The Secretary
NSW Planning, Industry & Environment

27 October 2021

I refer to the Department's below email of 18 October 2021 regarding the Environmental Impact Statement (EIS) for State Significant Development SSD-23330227 Upgrade to John Palmer Public School for 'Increase capacity from current existing 917 students to 1,012 students. It will provide for the formalisation of learning spaces in a new 3 storey building and associated facilities, hall, library and learning spaces' located at 85 The Ponds Boulevard, The Ponds NSW 2769 (Lot 1 DP 1131340) in the Blacktown City Local Government Area (LGA). Submissions need to be made to the Department by 15 November 2021.

Endeavour Energy's further recommendations and comments are as follows:

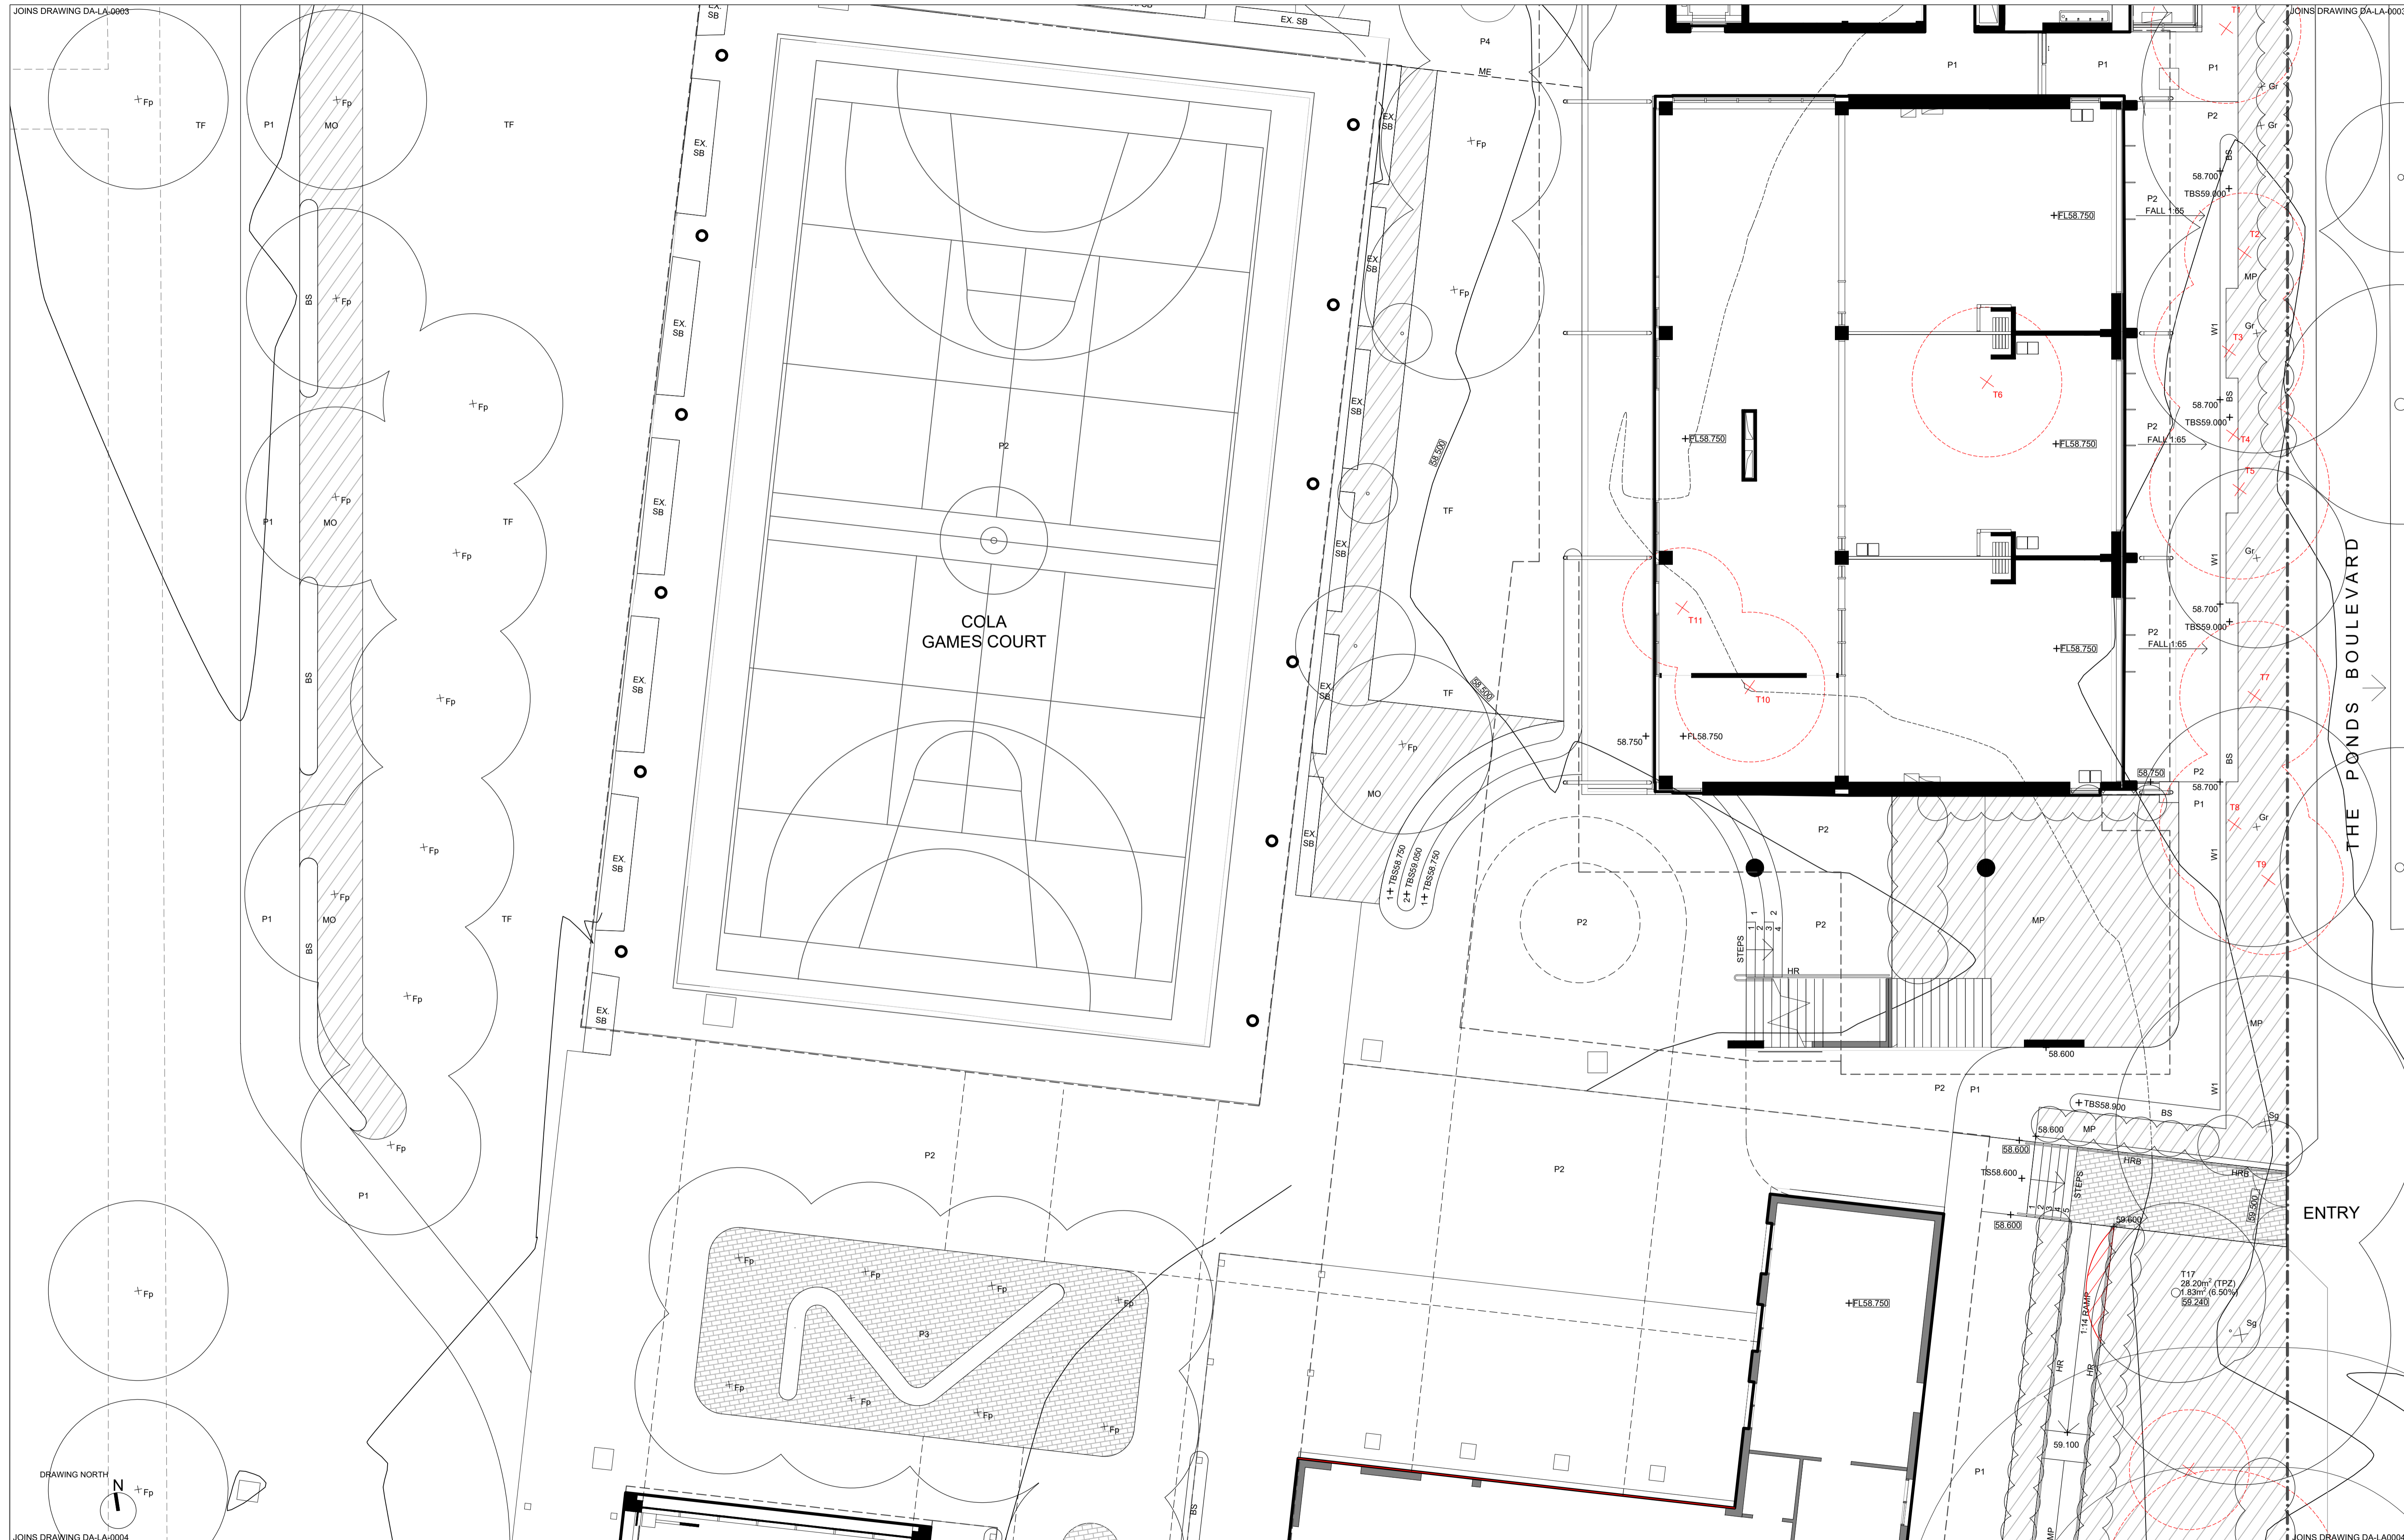
Trees 18 and 19 are located within the exclusion zone of the existing substation, along The Ponds Boulevard. Upgrade works are required to the existing substation as part of the John Palmer Public School development. All other trees identified for removal are located within proposed building zones.

Screening vegetation around a padmount substation should be planted a minimum distance of 800mm plus half of the mature canopy width from the substation easement and have shallow / non-invasive roots. This is to avoid trees growing over the easement as falling branches may damage the cubicle and the electricity infrastructure as do tree roots. All vegetation is to be maintained in such a manner that it will allow unrestricted access by electrical workers to the substation easement all times.
